Subject: Rezoning Petition Review

Rezoning Petition #: 21-215

Location of Property: Approximately 102 acres located on the north side of Mt Holly Rd and west of Belmeade Dr.

SCHEMATIC  
SITE PLAN

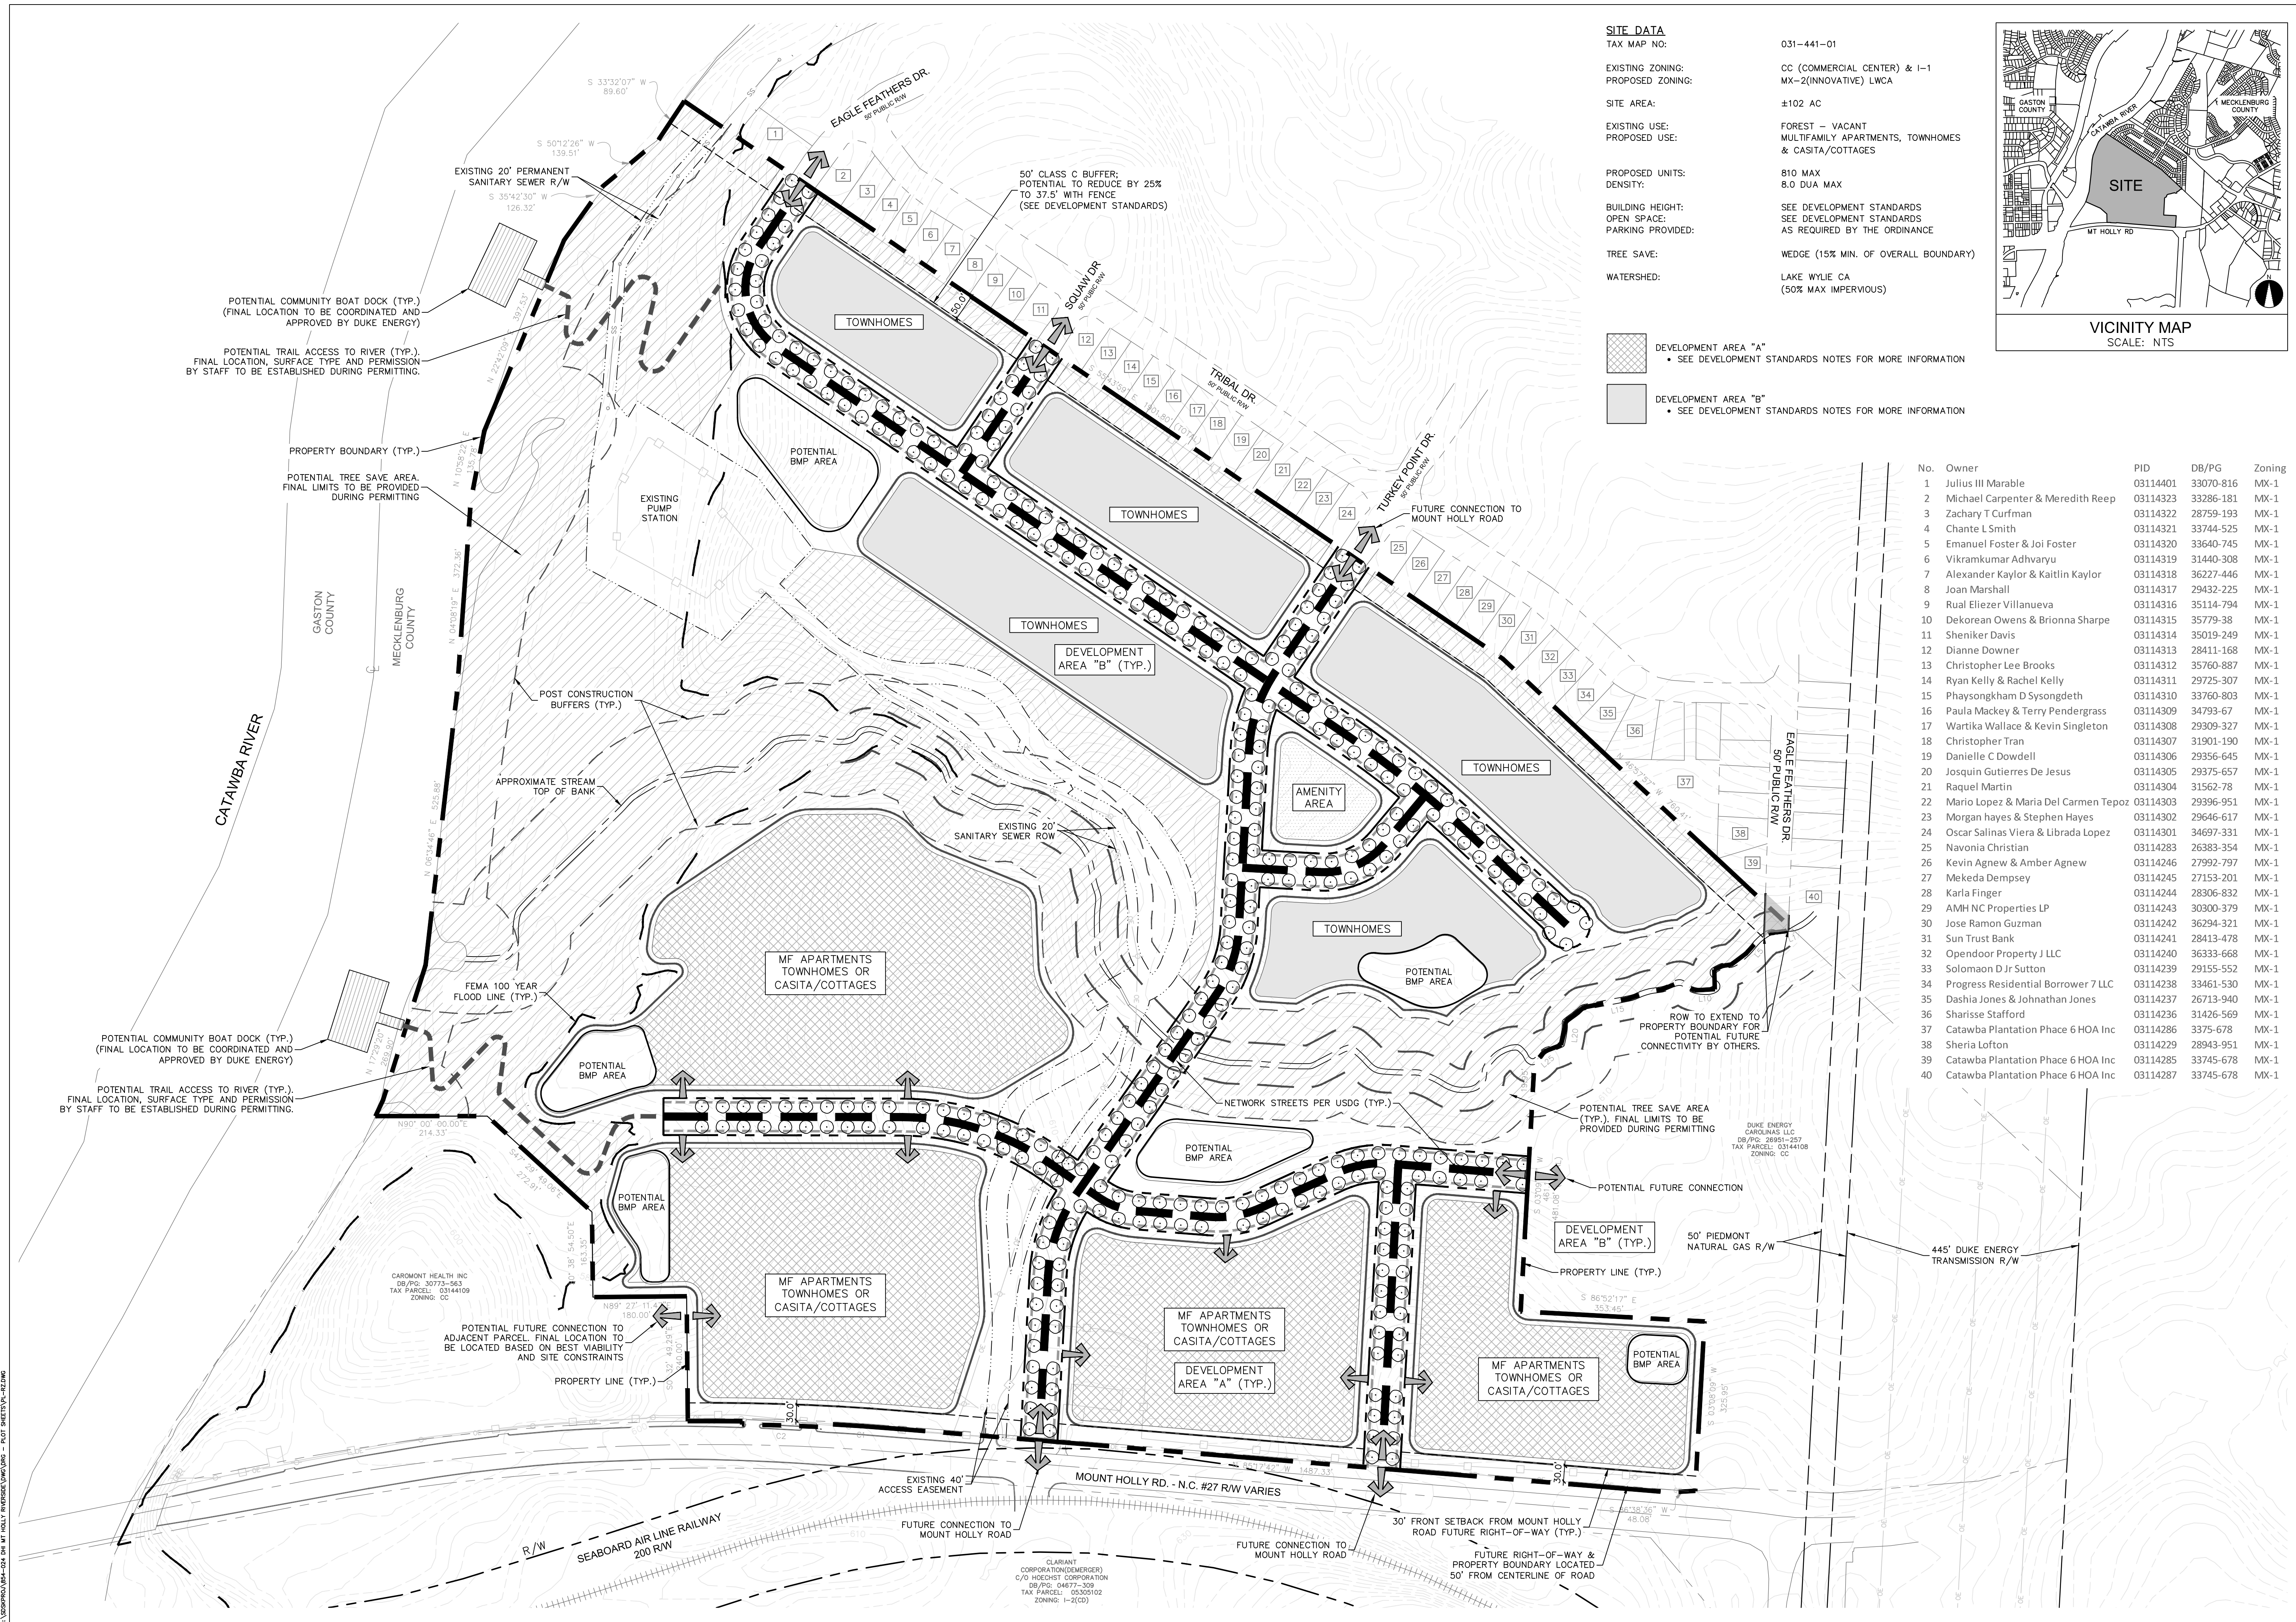
Please label (size and type) of all SWIM/PCSO buffers on site and include the following note on the site plans:

- Development within any SWIM/PCSO Buffer shall be coordinated with and subject to approval by Charlotte-Mecklenburg Storm Water Services and mitigated if required by City ordinance. Petitioner acknowledges intermittent/perennial stream delineation reports are subject to review and approval upon submission of development plans for permitting and are not approved with rezoning decisions.
